**Consultation Response from Mike Hibbert,
KC Waste Strategy(Refuse & Recycling)**

2023/93704 land northwest of, Urban Terrace, Denby Lane, Grange Moor, Huddersfield, WF4 4EB

Erection of 10 dwellings and associated works

Responding Ref: WPS 23-079

Site Plan for Application
(reference: 2021/62/94747/E)

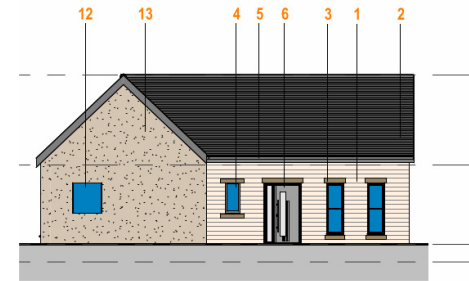
- On collection day the residents would need to transfer bins to a presentation point close to the adopted highway and not left on the footway.
- Plots 1,2 and 3 can present bin within their curtilage but adjacent to Denby Lane.

- Bin Collection Points are shown on the plan for Plots 4 &10 and Plots 5 to 9 (at the rear of the POS). To use these locations residents will have to drag out bins on collection day. It appears that for some plots the drag out distance would be more than the 25m limit specified in guidance BS5906:2005. It would be preferable for residents to present bins within their curtilage but adjacent to highway rather than use the collection points shown on the plan.

- Refuse collection vehicles RCV's will not routinely enter private drives unless they are constructed to adoptable standards.
- It is welcomed that there is provision of a turning head between Plots 6 and 9. Where turning is necessary, the turning facilities must be demonstrably sufficient for an 11.22m refuse collection vehicle. **Active measures should be taken to prevent parking in the turning head as otherwise an RCV would have a long reverse manoeuvre that is a recognised safety risk and is not acceptable.**
